Please ask for: Sian Eggington
Email: sian.eggington@terraquest.co.uk
Telephone: 0121 234 1390
Our Ref: AW/421/21/HH
Your Ref:
Date: 7th February 2022

Application for Planning Permission for Works or Extension to a Dwelling

Development: Single storey rear extension.
Location: 23 The Drive Aldwick PO21 4DU

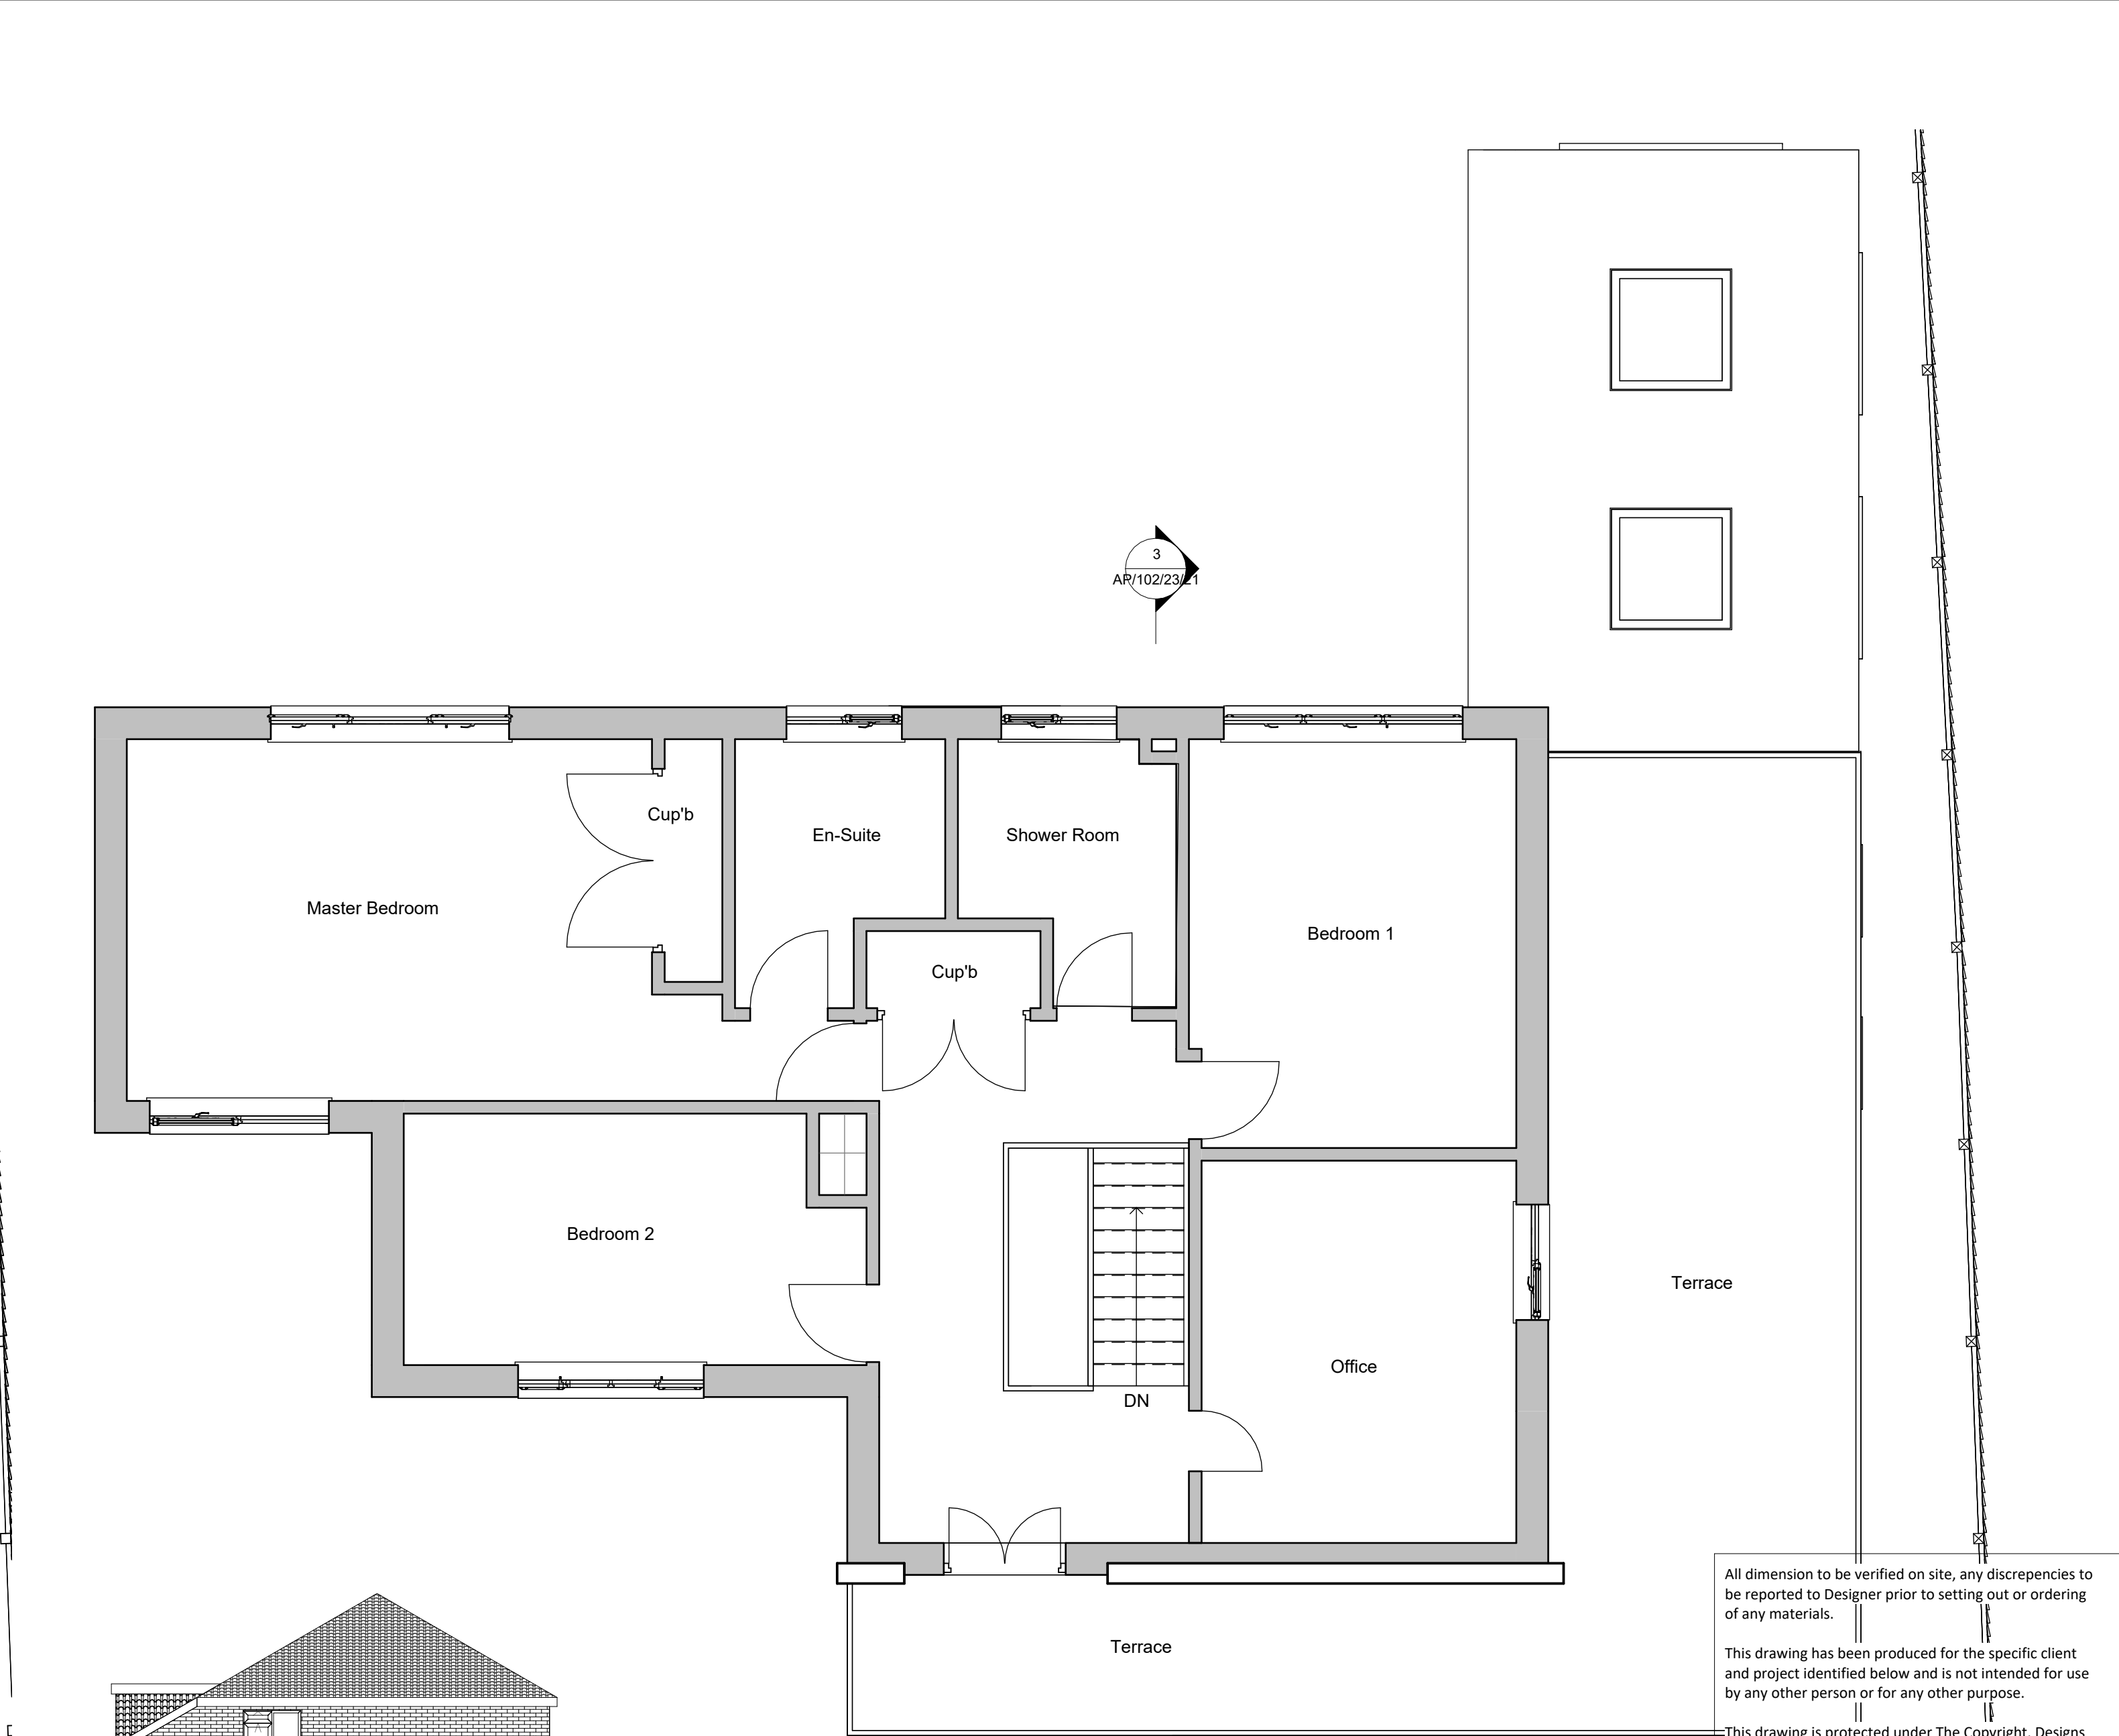
Dimensions: You are required to include dimensions on the block plan from the proposed extensions to all site boundaries.
